**re: Geotechnical Design Summary Details**  
**Proposed Residential Building**  
**2458 Cleroux Crescent – Ottawa, Ontario**

**to: Melmar Group – Mr. Marc Nakhle – [info@melmargroup.ca](mailto:info@melmargroup.ca)**

**date: July 20, 2023**

**file: PG5973-MEMO.02**

Fig. 10. Proposed Grading Plan for 2458 Cleroux Cres.

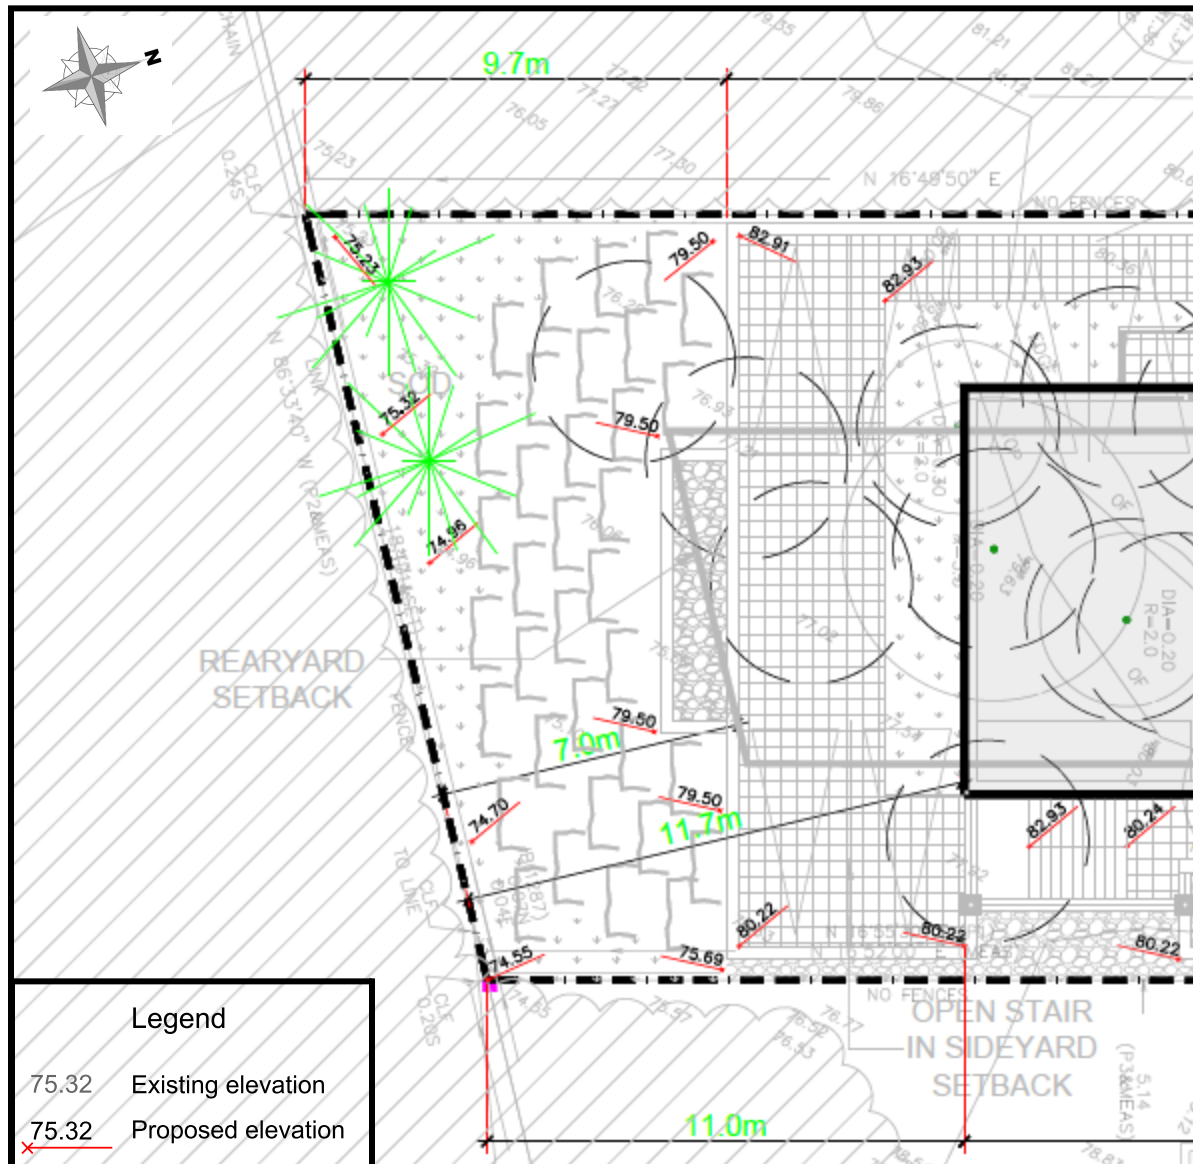
Further to our review, the proposed finished grade along the rear side and throughout the parking area of the proposed building would result in an exceedance in the recommended permissible grade raise restriction provided in the aforementioned Geotechnical Report. Lightweight fill (LWF) has therefore been recommended to accommodate the proposed grading throughout and along the rear portion of the building.

The LWF should consist of EPS (expanded polystyrene) geofoam blocks consisting of a minimum EPS type 19 block for these purposes. The LWF should be placed throughout the indicated area of the building footprint a minimum of 500 mm below the subslab fill layer. The entire LWF layer footprint is recommended to be covered with a layer polyethylene which should further extend a minimum of 300 mm below the LWF layer surface. Placement of LWF should be upon a leveled surface and reviewed at the tie of construction by Paterson personnel.

Reference should be made to Figure 1 – Lightweight Fill Recommendations attached to the end of this memorandum for a summary of the proposed installation methodology information.
